Department of Transportation

August 31, 2023

RE: AL2318 - Special Use - Monument Glamping II

I am in receipt of a referral request for Monument Glamping II located at 14545 Hwy 83 (R-A MP 27.60), Town of Monument, in the County of El Paso, State of Colorado. The project proposes to construct 12 Glamping Units with personal bathrooms on 5.9-acres. The property will have a septic and leach field. **There will be one full movement access points on state highway 083A. In preparation of the future improvements and in compliance with the Access Control Plan for state highway 083A, they will be required to establish and record a cross lot access easement.** The property has the tax schedule No. 6100001112, currently owned by Randy & Linda Amann. After review of submittals we have the following comments:

Monument Glamping II
18045 HIGHWAY 83, COLORADO SPRINGS, CO 80908

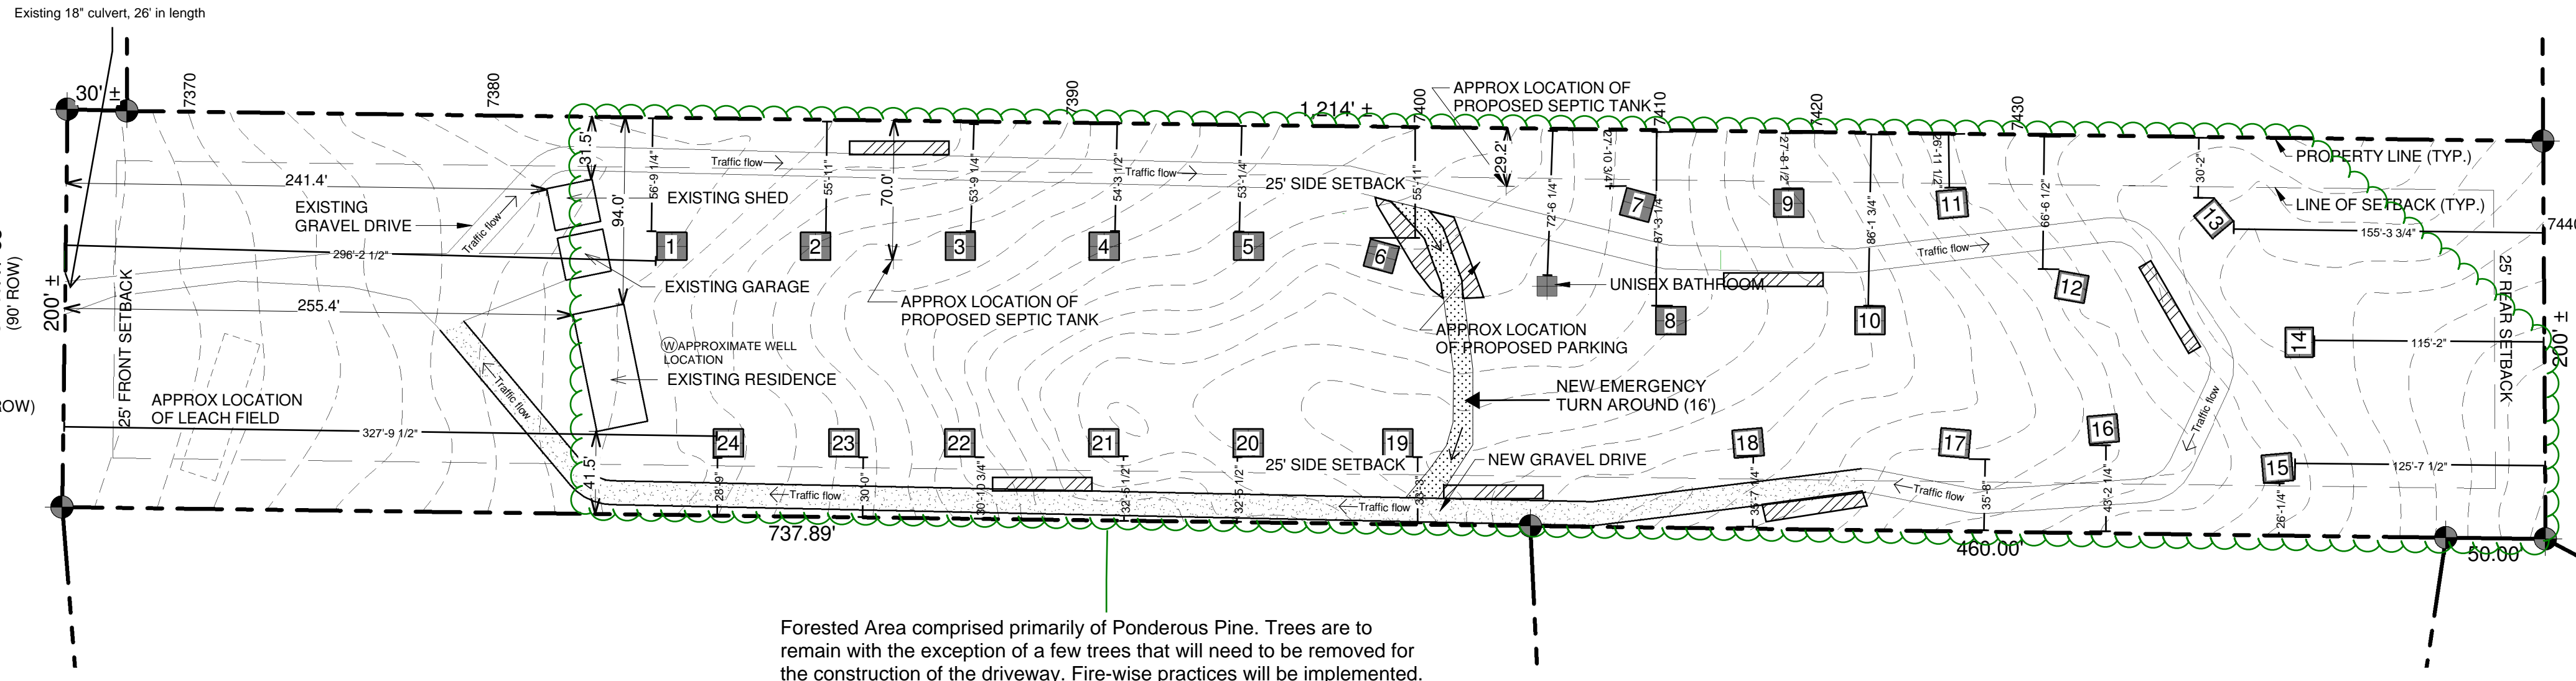
- Trip generation is acceptable.
- The intended access does not comply with the access control plan for state highway 083A. The approved plan indicates cross lot access to Walden Way.

- A CDOT Access Permit (223018) was issued in May of 2023. The Notice to Proceed has not yet been issued.
- Dedication of a 30-foot access easement parallel with state highway 083A shall be established and recorded with El Paso County before the Notice to Proceed issuance.
- See attached Exhibit D and Exhibit E of the Highway 83 Access Control Plan.
